East Anglia ONE North and East Anglia TWO Offshore Windfarms

Applicants' Comments on Tessa Wojtczak's 11 Submissions

Applicant: East Anglia TWO and East Anglia ONE North Limited
Document Reference: ExA.AS-28.D12.V1
SPR Reference: EA1N_EA2-DWF-ENV-REP-IBR-001127

Date: 28th June 2021
Revision: Version 1
Author: Royal HaskoningDHV

### Bat Roost and Commuting/Foraging Habitat Results

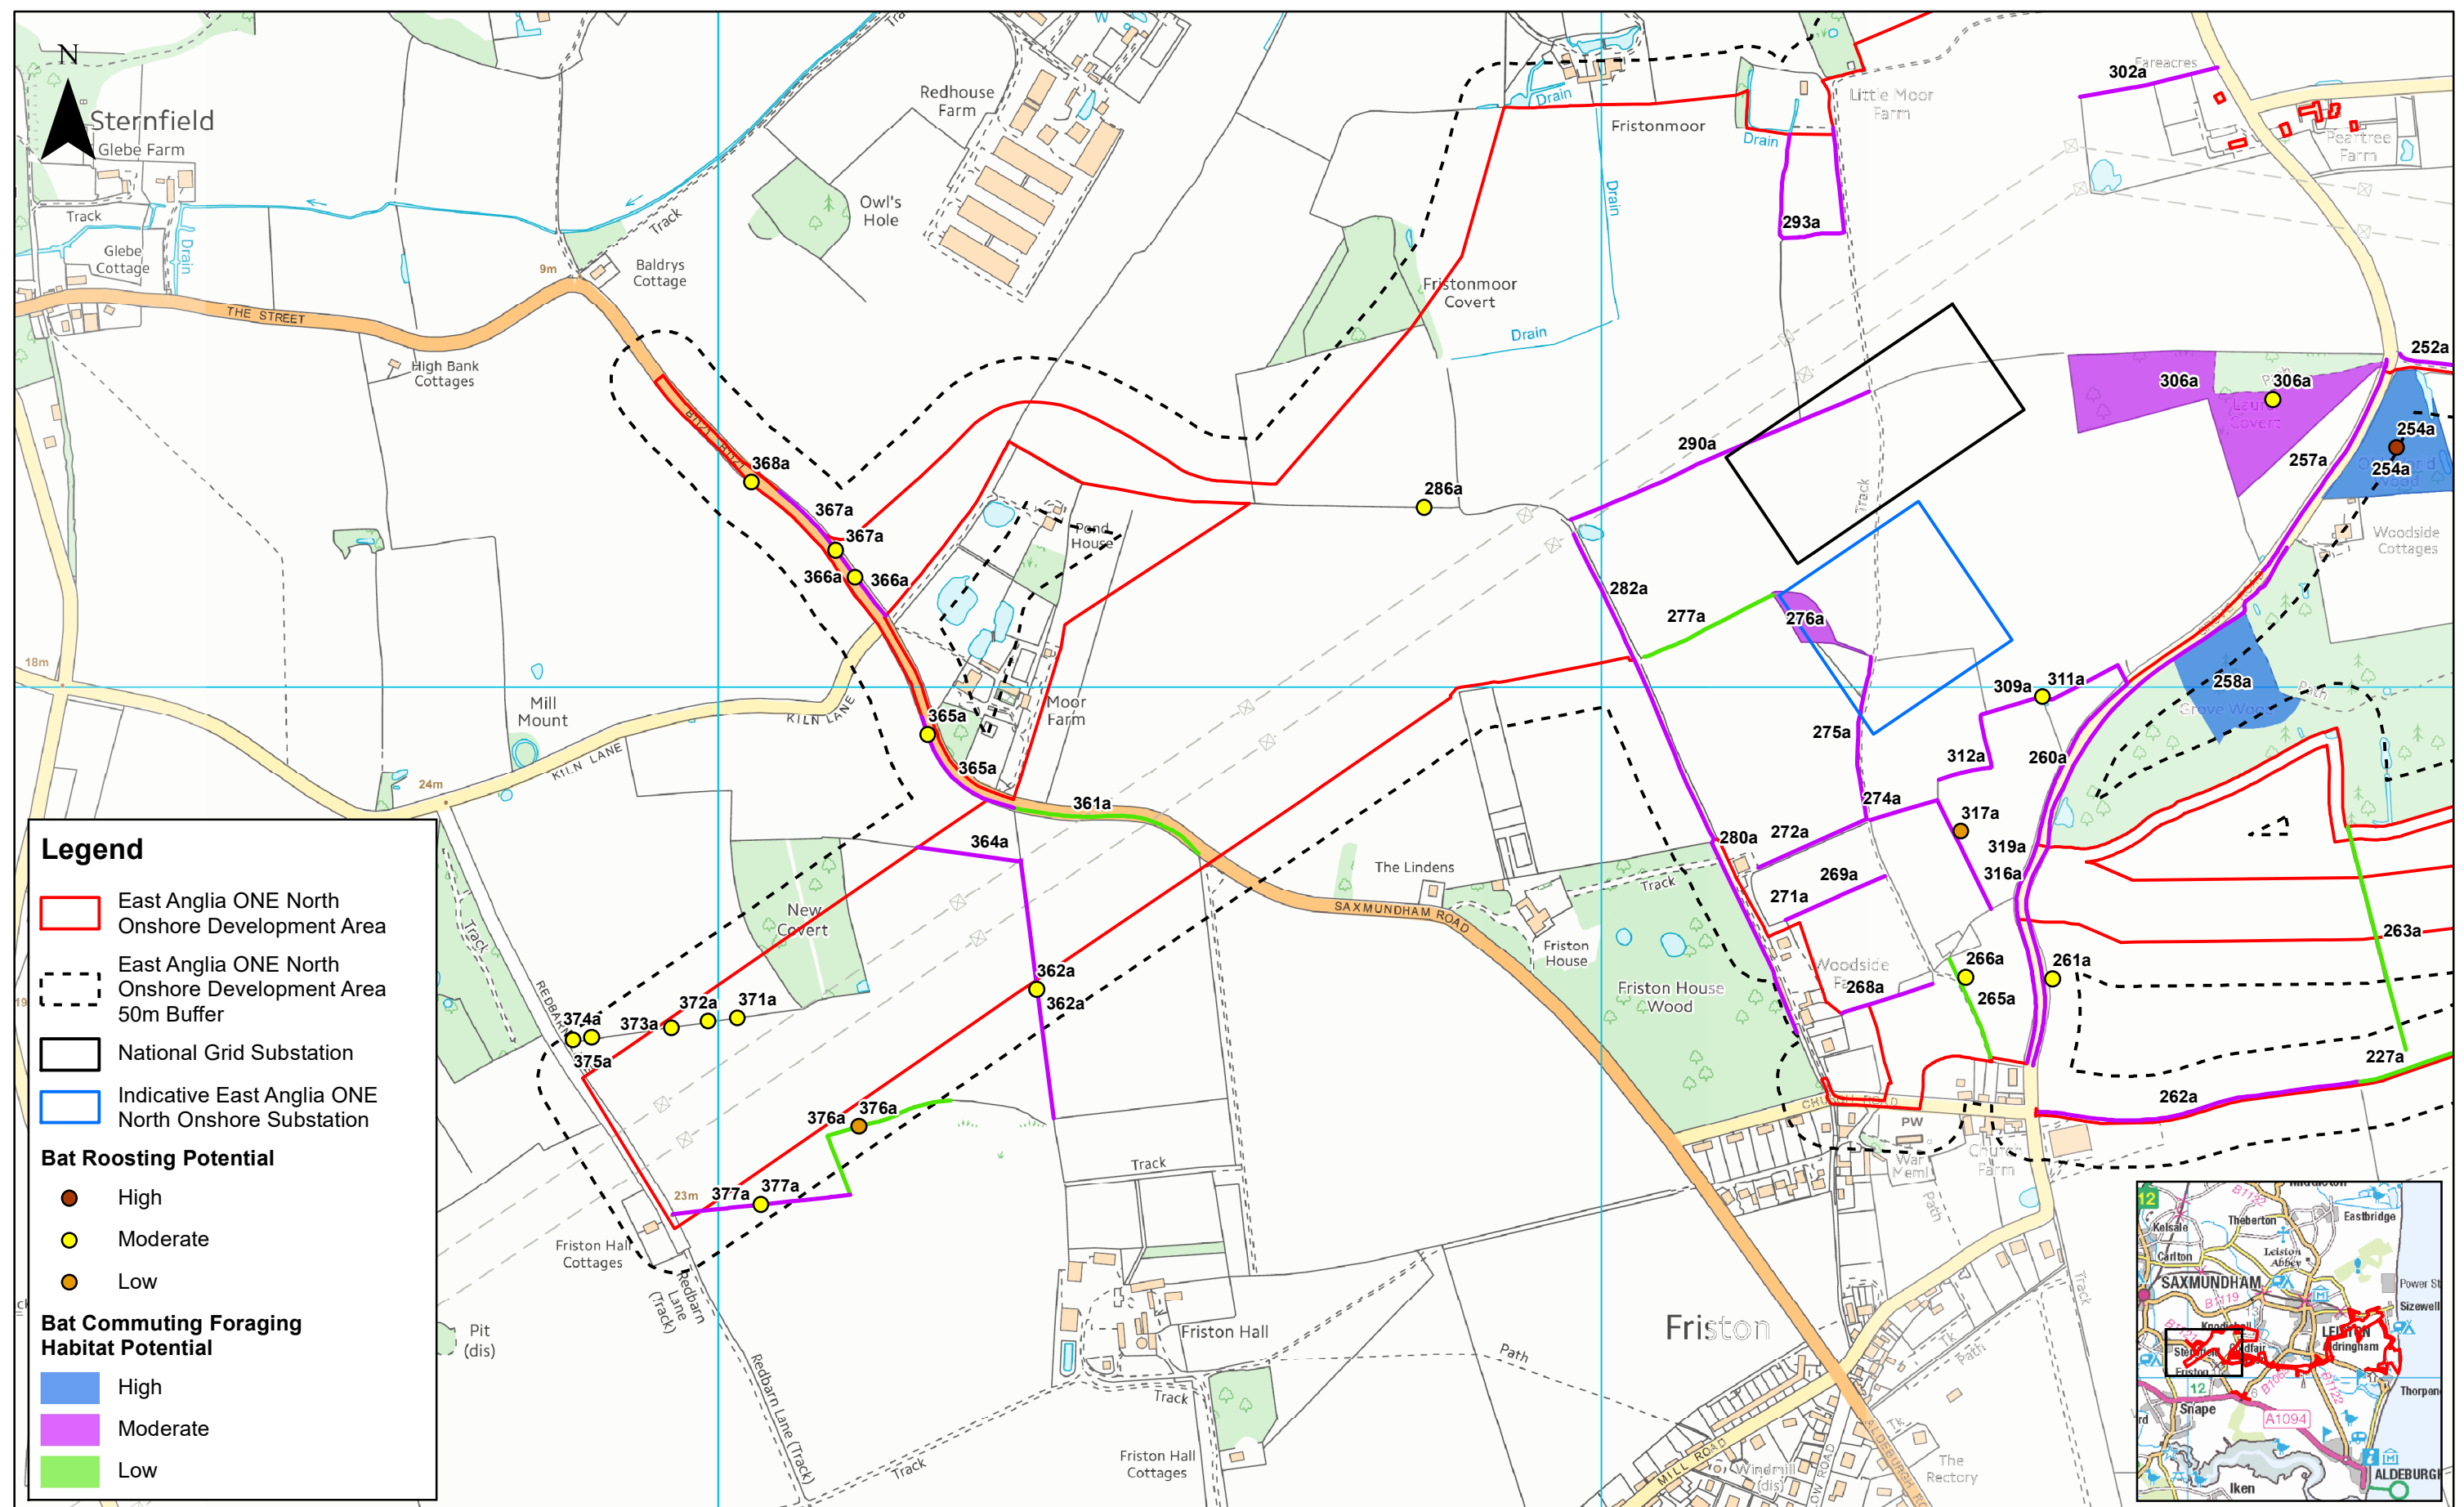
9	<p>Impact 9 , Bats states that no confirmed bat roost sites have been recorded within the Onshore development area.</p> <p>This in itself is remarkable given the extent of that area. However, the Applicants translates that lack of recording of confirmed bat roost as a conclusion as “an absence of this species at this location.”</p>	<p>Ms Wojtczak misrepresents the information within Change Request: Amendment to Order Limits at Work No. 9 (Plot 13) (AS-104). Where practicable, development of the Order limits sought to avoid environmental sensitivities (e.g. potential bat roosts). AS-104 notes that bat activity was observed during surveys across the onshore development area, and that foraging / commuting bats were detected at survey locations near to the coast.</p> <p>The area of land brought into the Order limits by the realignment has no bat roost potential (being the centre of an intensively farmed arable field). There is a single hedgerow (potential bat commuting feature) present within this stretch of</p>

ID	Tessa Wojtczak's Comment	Applicants' Comments
	<p>At present there is, as there is every year, constant and prolific activity of pipistrelle bats in our garden, along the track and across all the fields adjacent. It is a false conclusion; and yet it stands</p>	<p>the Order limits; the realignment will require the removal of a shorter section of this hedgerow than previous. Therefore, the assessment conclusions regarding bats within Chapter 22 Onshore Ecology (APP-070) remain valid.</p>
10	<p>Impact 10. Great Crested newts (which we have observed, apparently emerging from Plot 13 and approaching the pond at Wardens). The Applicants state that “ aquatic habitats are not present at this location “.</p> <p>The Panel has seen the wildlife aquatic pond directly over the fence from Plot 13 at Wardens; not within the Order Limits, but surely of significance in this respect as habitat for Great Crested Newts. Again, the statement does not reflect the reality, and yet it stands within the ES.</p>	<p>See Applicants' response at ID8.</p>
